Our ref: DOC20/697329

Your ref: SSI-9371

Exhibition of the Inland Rail North Star to NSW/Queensland Border Environmental Impact Statement

Inland Rail North Star to NSW/Queensland Border – Environmental Impact Statement

FIGURE 11.3A-P FIELD VERIFIED PCTs AND BAM PLOT LOCATIONS

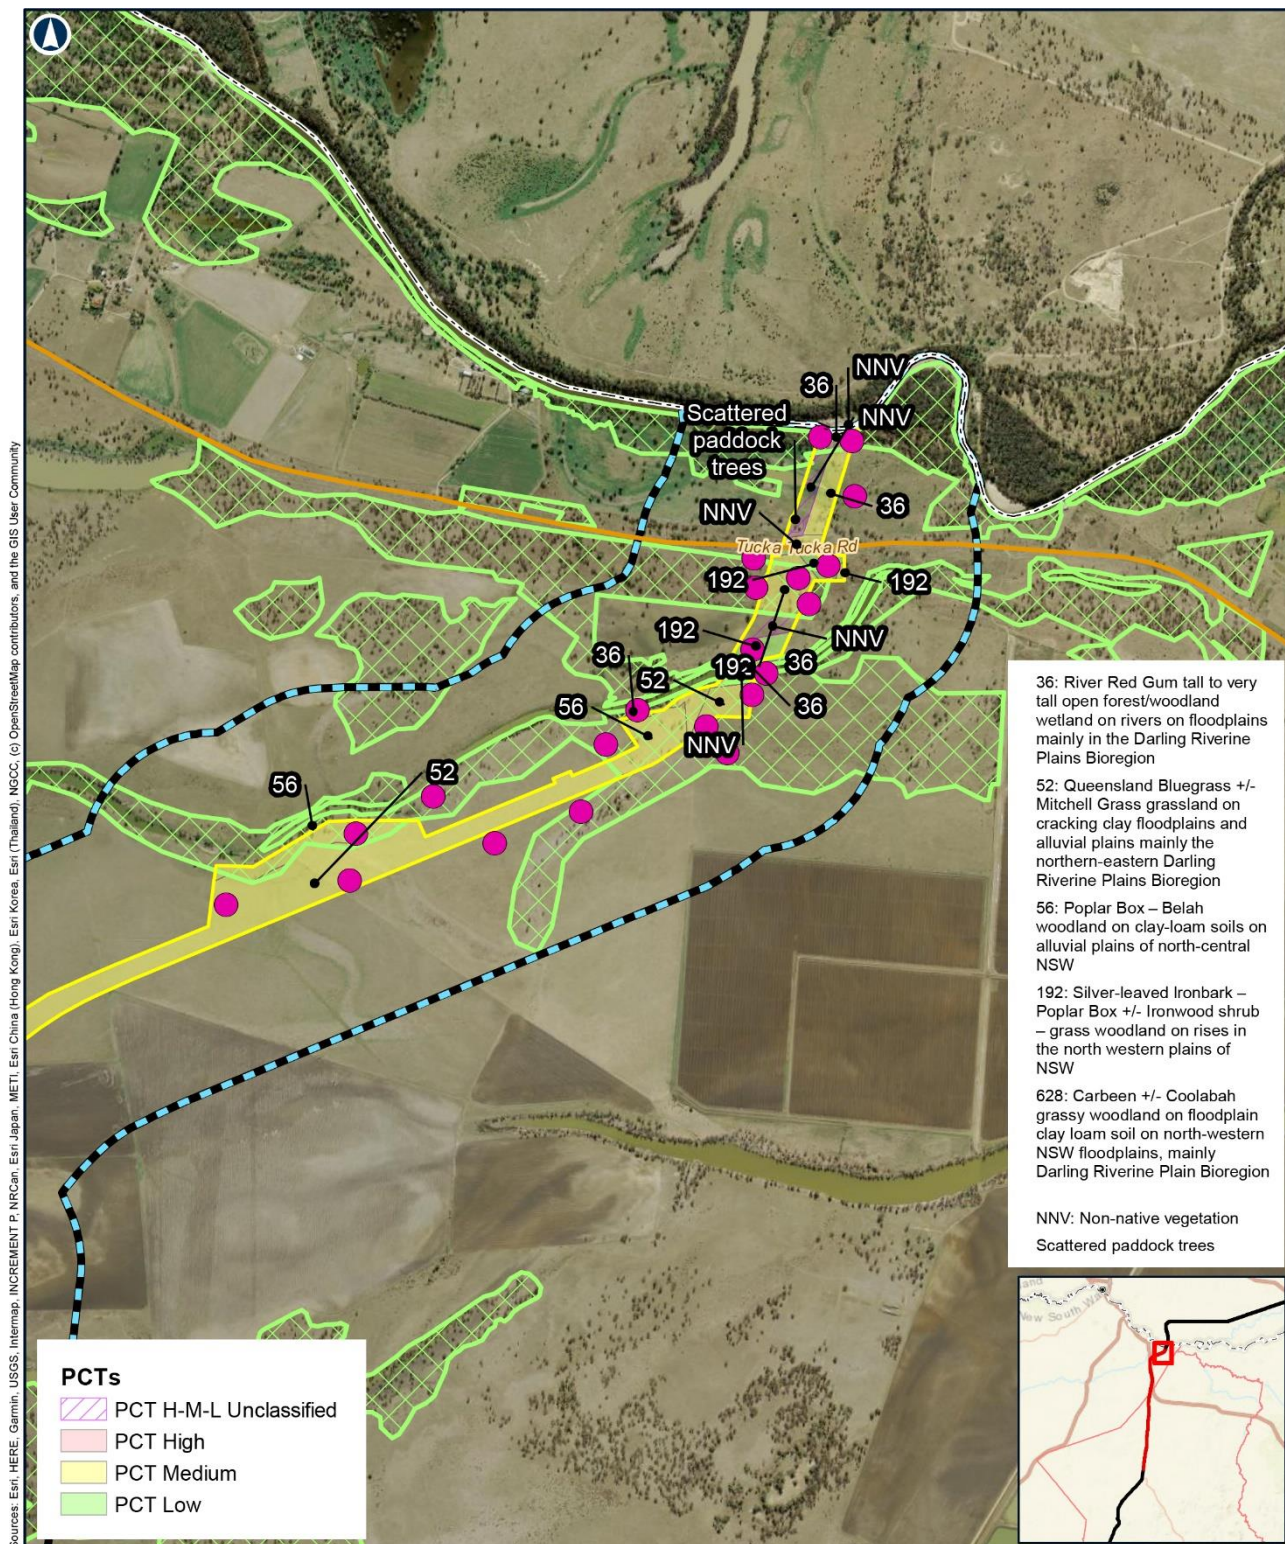
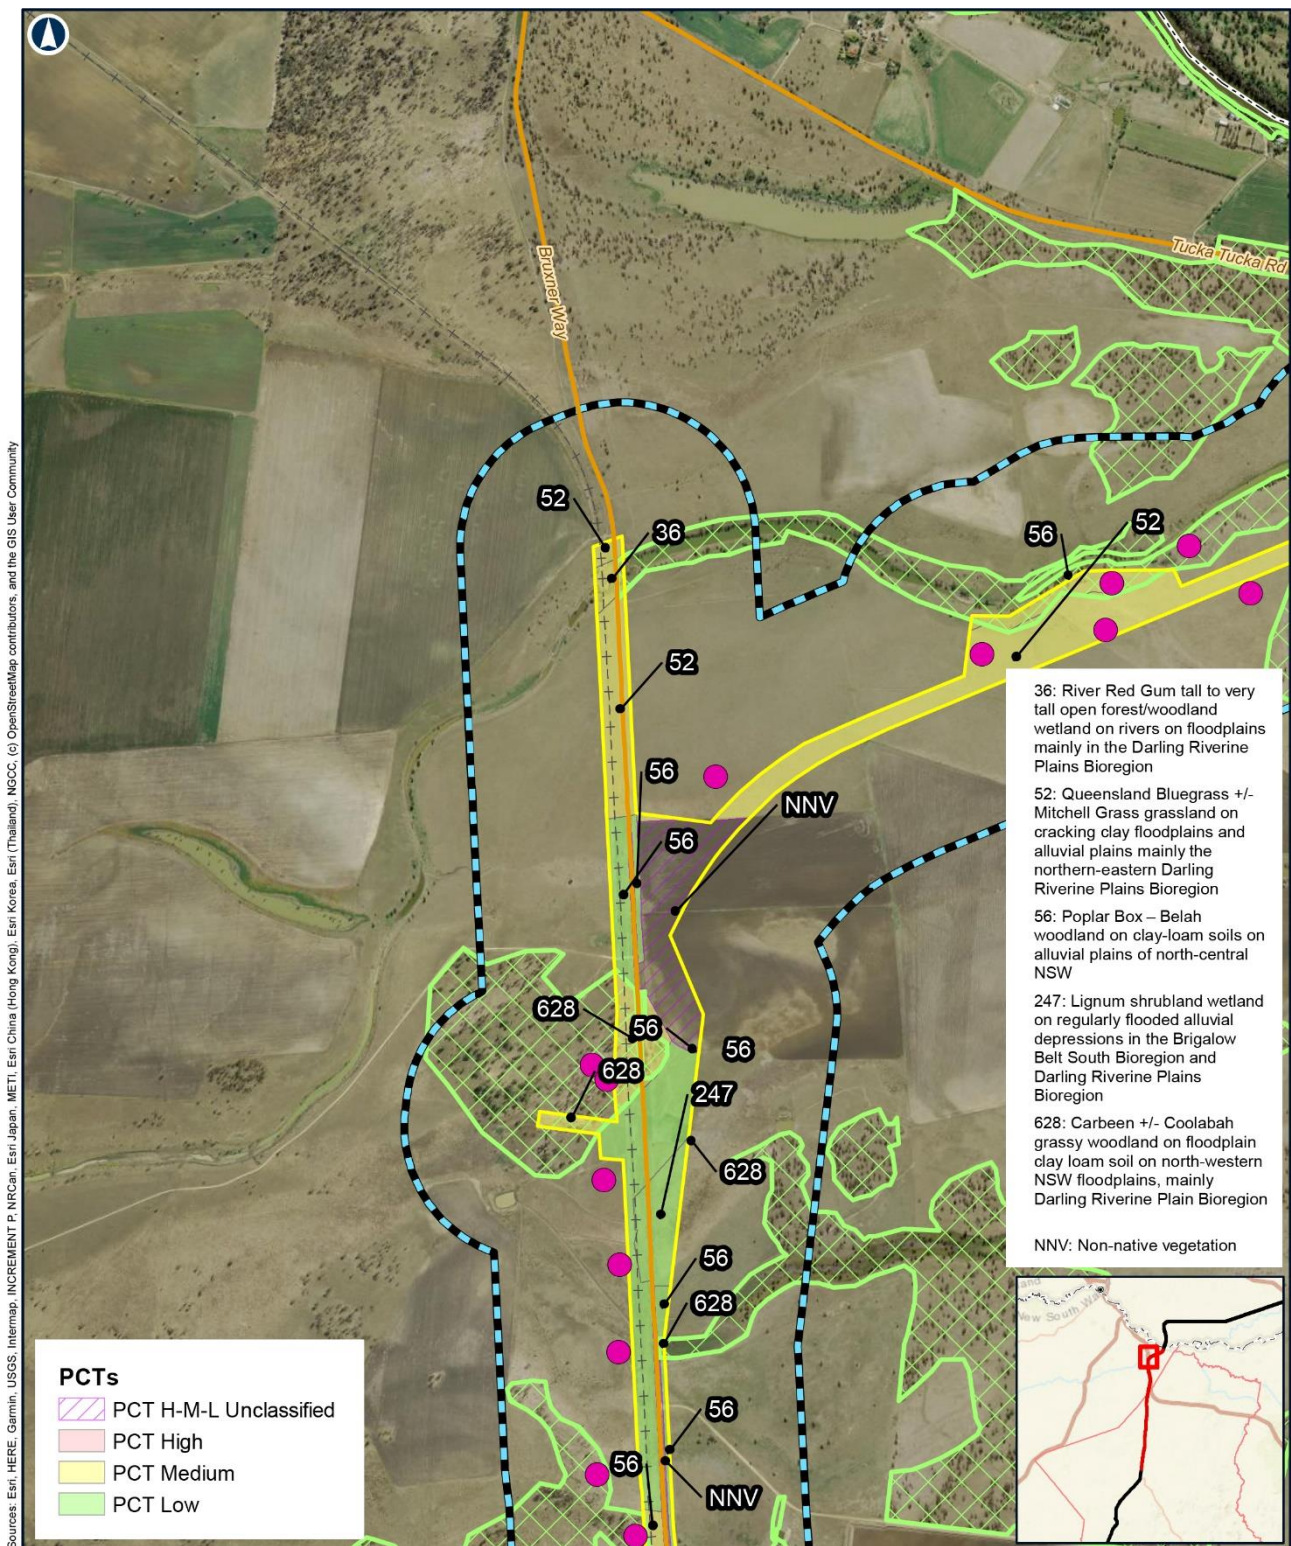
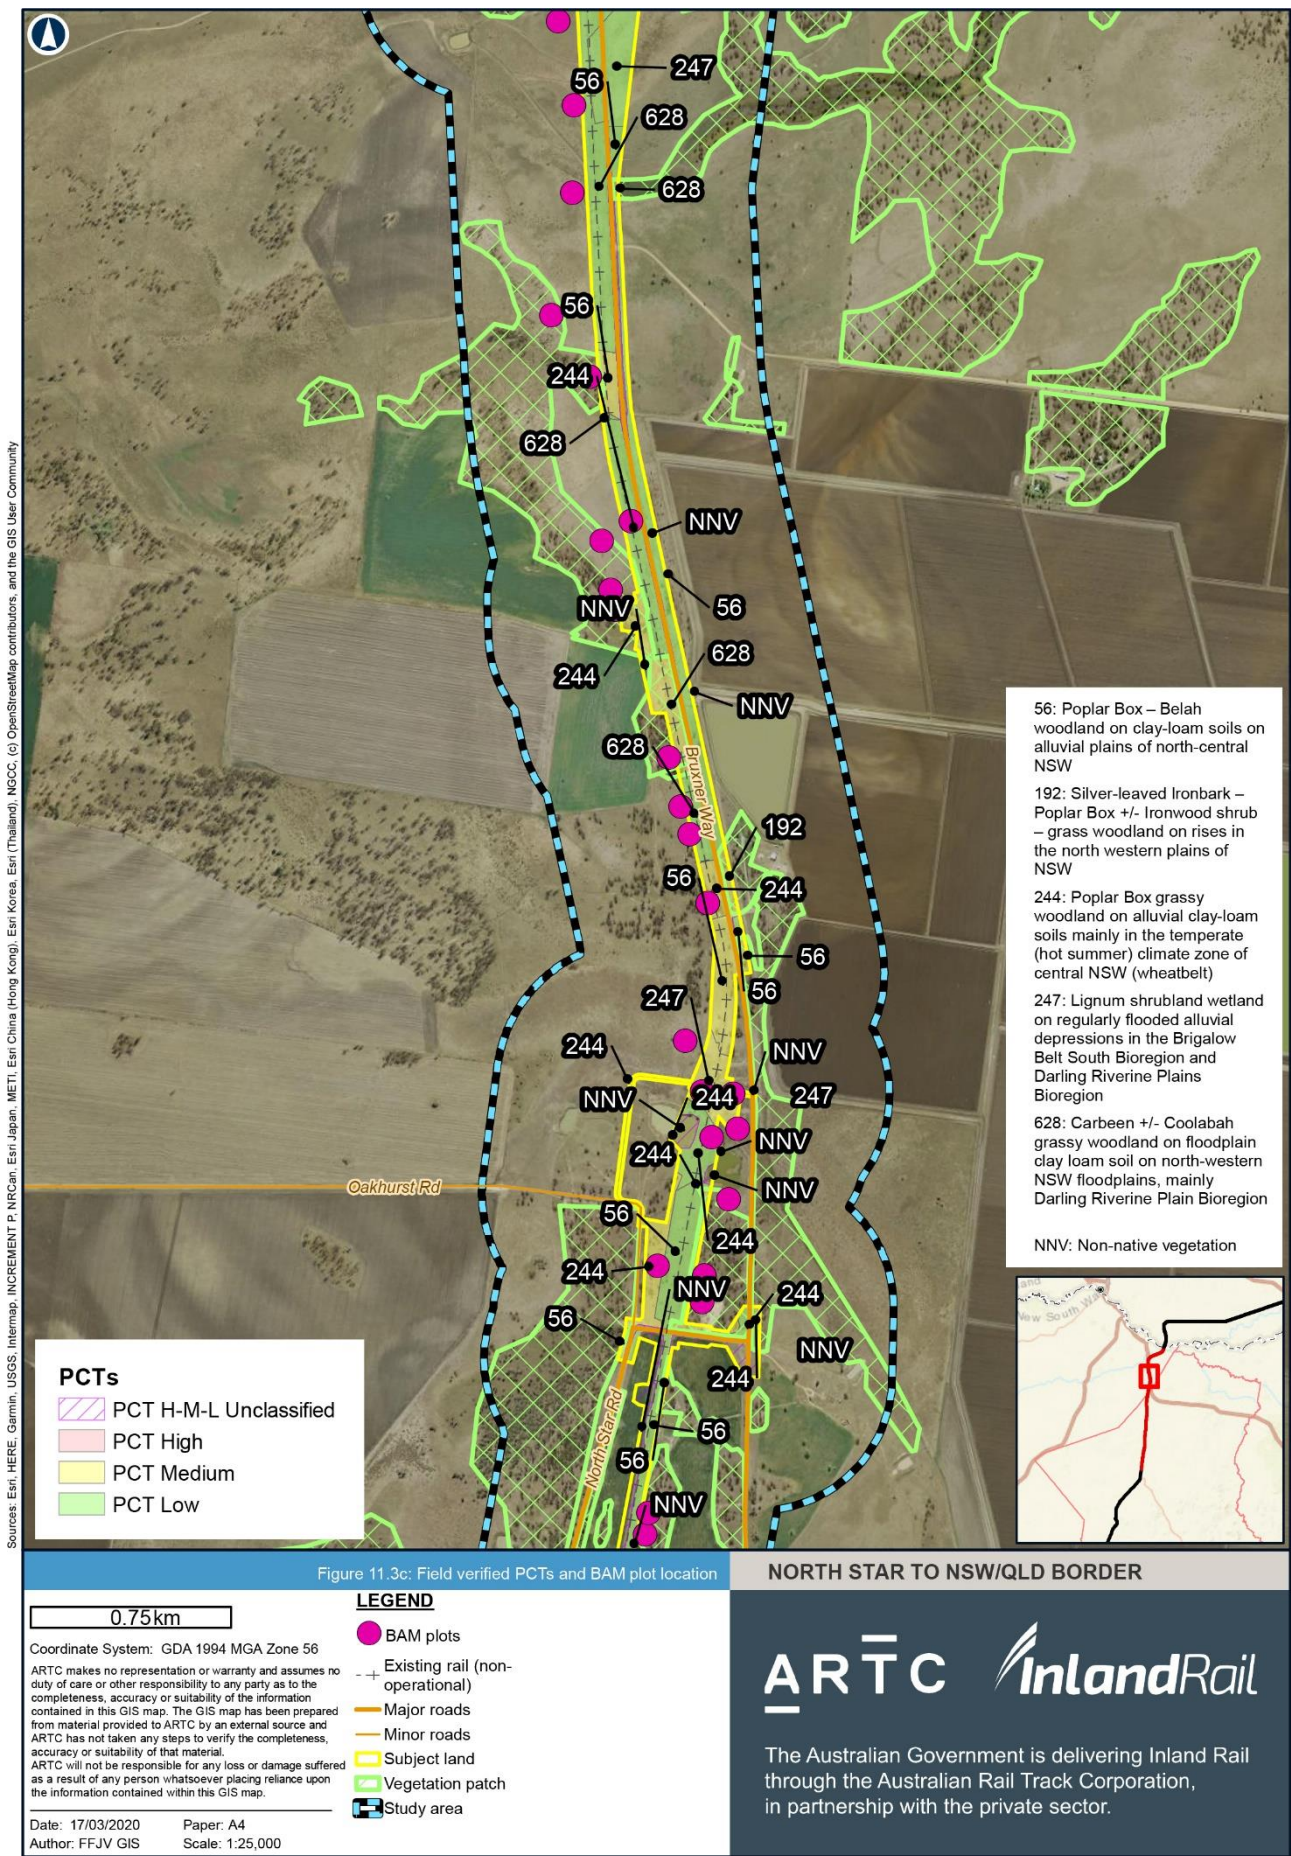
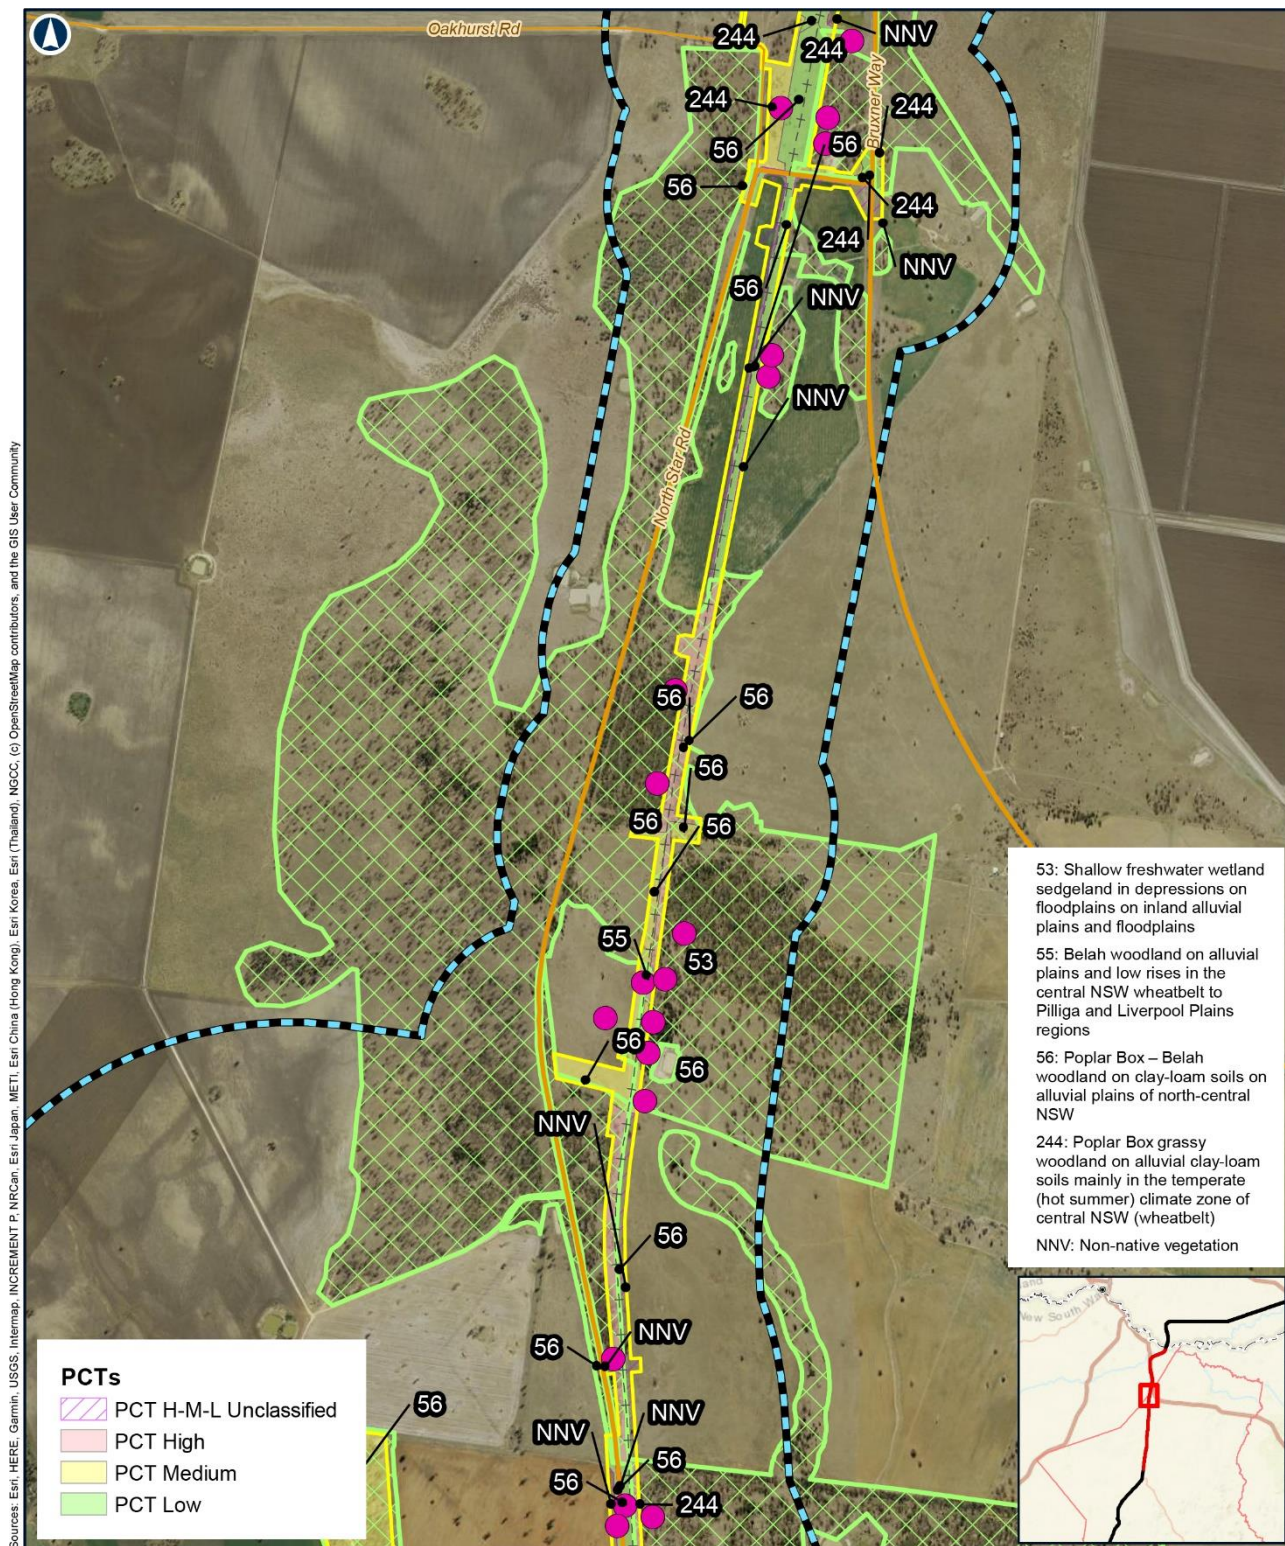
- 21.1 Explain why there are multiple sets of data for the same Plot ID.
- 22.1 The location of all plots should be reviewed to ensure that they conform to BAM. Where relevant, justification should be included in the BDAR to explain the selection of transect locations.

- 23.1 Information entered in the BAM for plots Z5P1 and Z5P2 should be reviewed, and the validity of using plot BP1LowP1 should be reviewed.
- 24.1 Review vegetation mapping to ensure that it correctly reflects the plot data collected.
